Subject: RE: 13-17 Abbeyfield, Richmond Avenue, Bognor Regis - TPJ Developments Ltd - BR/48/22/PL

DRAWING
LOCATION PLAN
SITE PLAN
DRAWING No
313/101
SCALE
DATE
1:1250 1:500
FEB 2022
DRAWN
CHECKED
LA

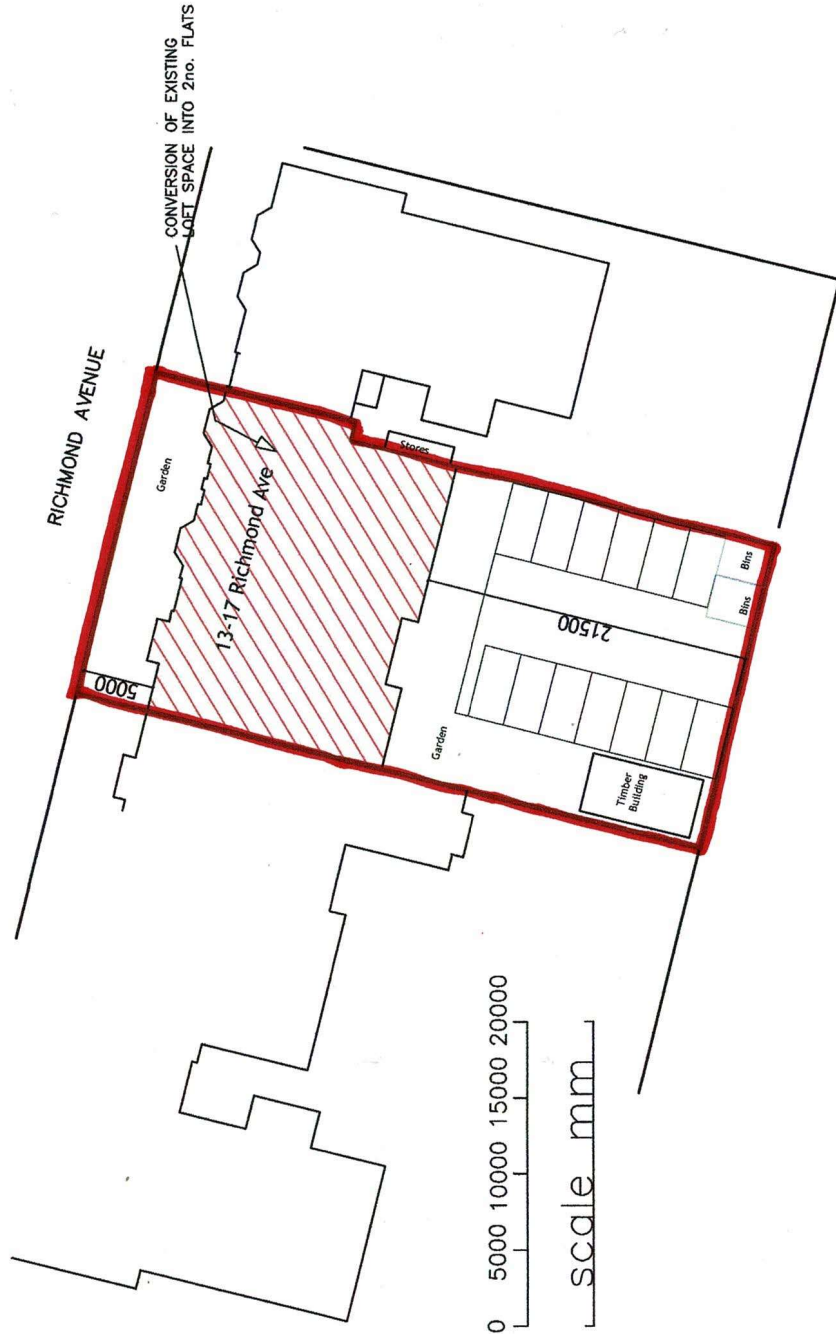
However, can you advise (a) whether works have commenced and if so what stage they are at; and (b) can you confirm that the changes result in the loss of the two private amenity spaces for flats 1/3 at ground floor as I note the parking area is being enlarged and appears to be around 3m closer to the building but there isn't the same level of detail re the ground floor external area on this application as there was previously.
